Supplementary comment re landscape and LVIA matters - application number 2020/62/93954/W - Lingards Road

Please see attached a supplementary planning comment from the Lingards Road residents committee. Other supplementary comments will follow.

This supplementary planning submission relates to the landscape and visual impact issues inherent in the revised proposals submitted by the applicant on 20th October 2022. It should be read in conjunction with all our previous comments regarding the landscape and visual impact of this development. For clarity we re-iterate that:

SITE AT LINGARDS ROAD - PROPOSED HOUSING			
CLIENT - S.B. HOMES LIMITED			
William Best RIBA		SITE SECTIONS A, B, C	
The Chapel House, 22, Pole Gate, Scammonden, West Yorkshire, HD3 3FW. Tel 01484 845896 Mob 07828 461144		SCALE	DATE
		1:200 WB	17/01/2020
		2019-572-13 G

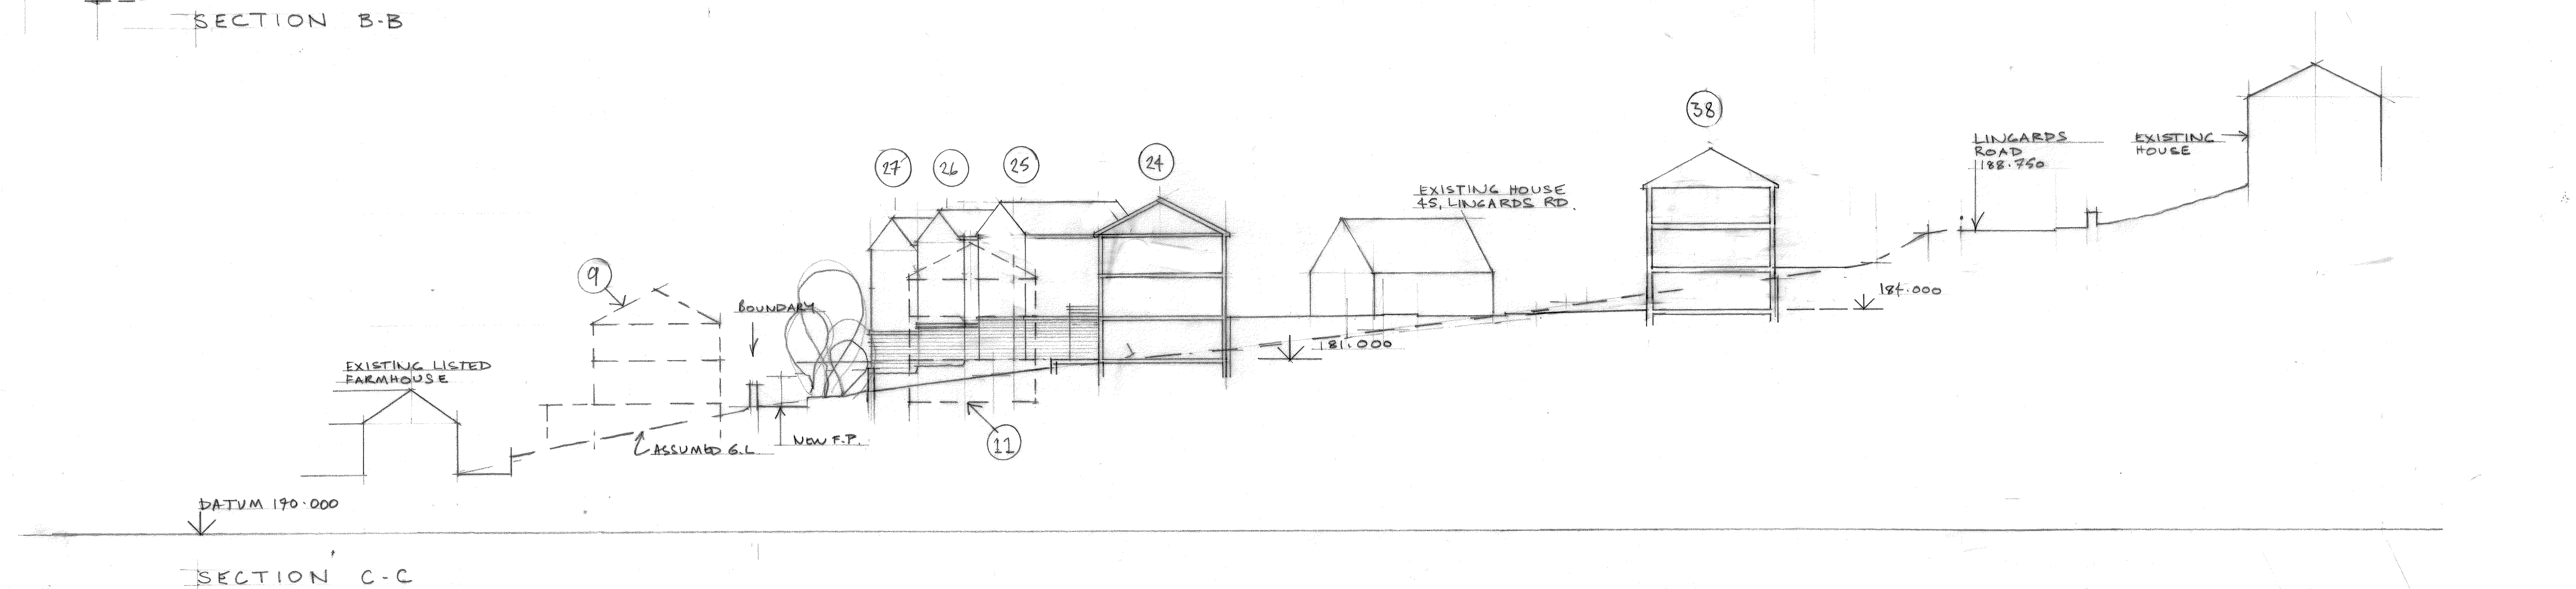
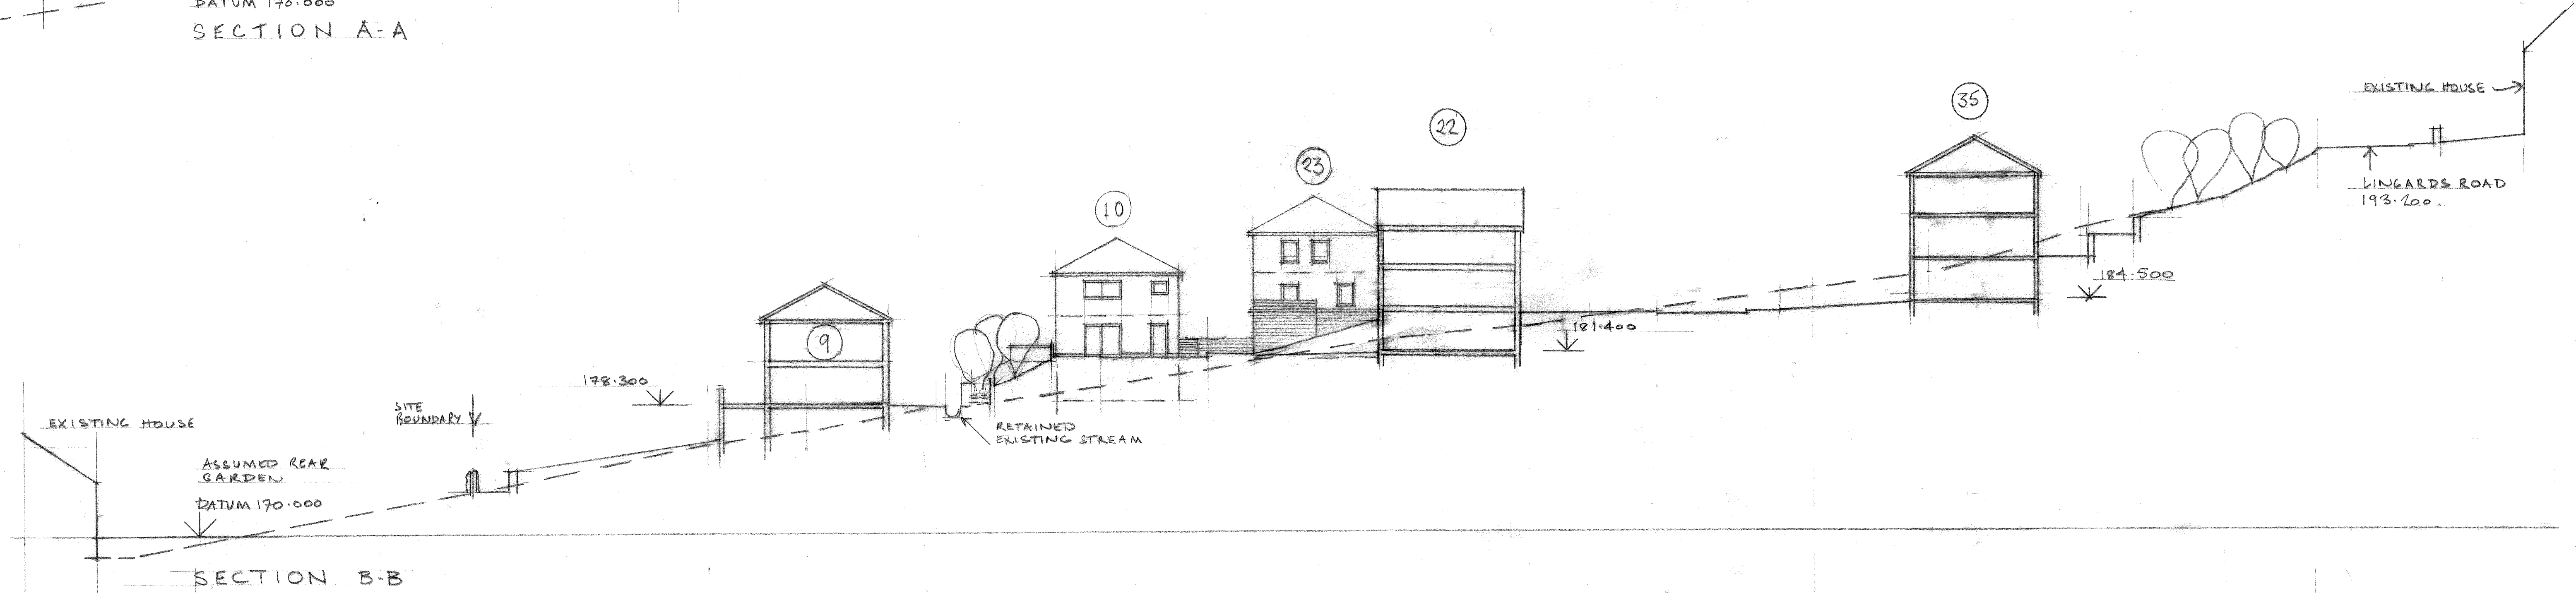
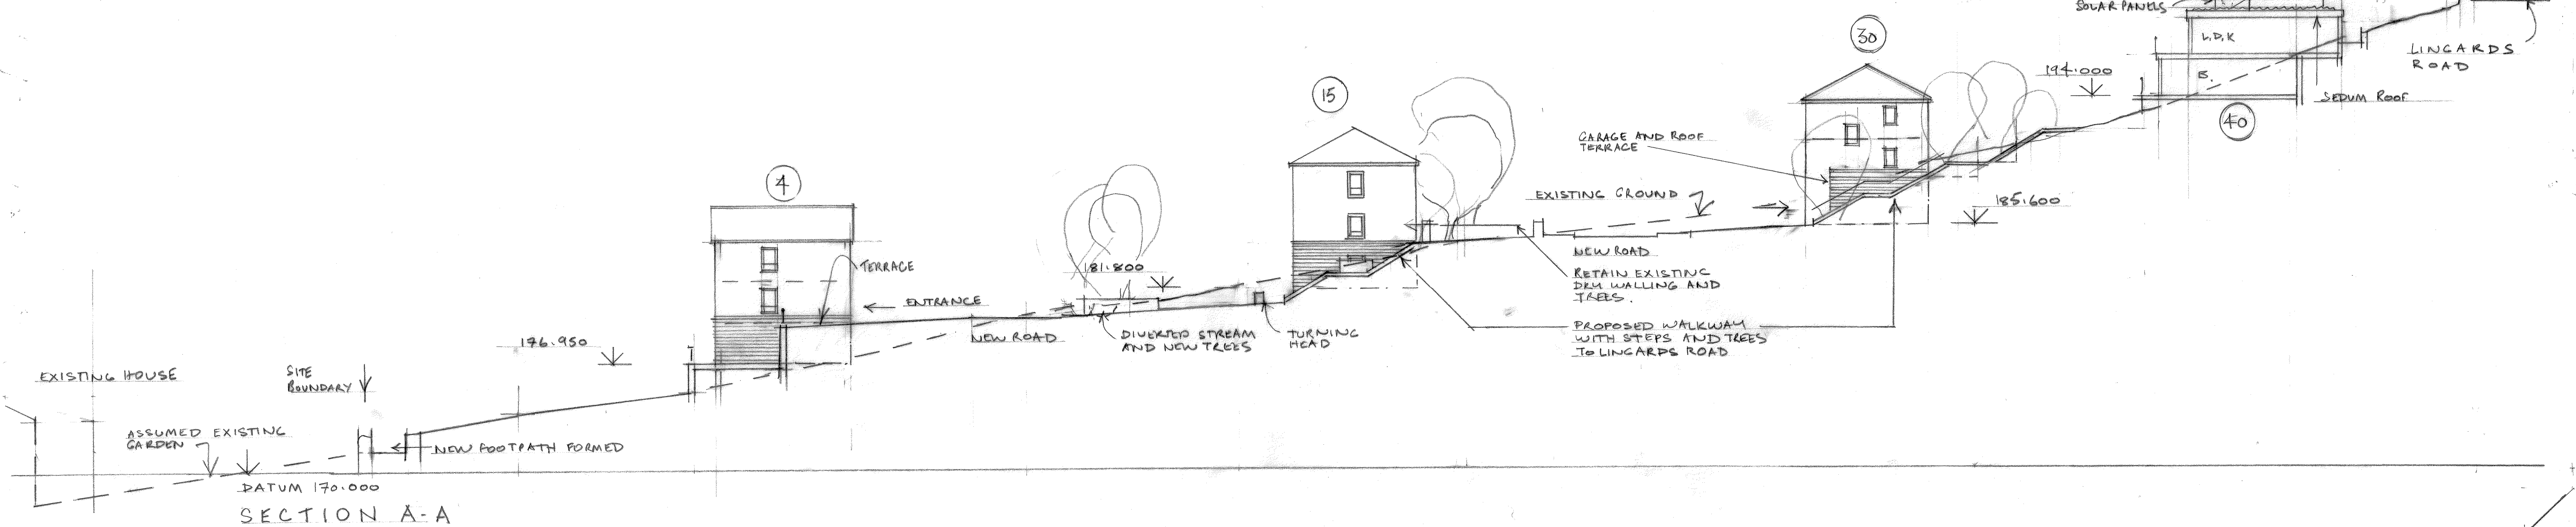
- **Invasive overlooking of houses on Manchester Road and Far Lower Wood Farm.** One of the more distressing aspects of the proposed development is how the three storey properties on the lowest tier of development still dominate and severely overlook the existing properties on Manchester Road and Far Lower Wood Farm. This is largely because of the steep slopes, the unacceptable housing density, the unacceptable height of three storey houses and the developer's penchant for balconies on the Northern elevations of the new properties. The developer may have “tinkered” with some of the fine details of the properties in this lower tier, particularly in his later planning iterations, but he has studiously neglected to address the fundamental problems. The impact of the development on the listed buildings at Lower Wood and Far Lower Wood Farm is of course a special case that is subject to other legal restrictions. We are pleased that the developer has now finally accepted that the development does cause harm to the listed buildings (see section 3.3.3 of the developer's Design and Access Statement) but are aghast at his unfounded assertion that ***“this is mitigated by the measures taken described above and results in only minimal harm to the historic setting and, when set against the public benefits of the scheme, justify the proposals”***. As usual, the developer fails to understand and make adjustments for the magnifying impact of the severe slopes and the three-storey form of houses on the site. In this context the minimal gaps between the listed buildings and the new buildings are insufficient to prevent unacceptable harm to the setting of the listed buildings. In our view the harm to listed buildings cannot and should not be so easily traded off against spurious “public benefits of the scheme”. We also feel that much more could be done to incorporate
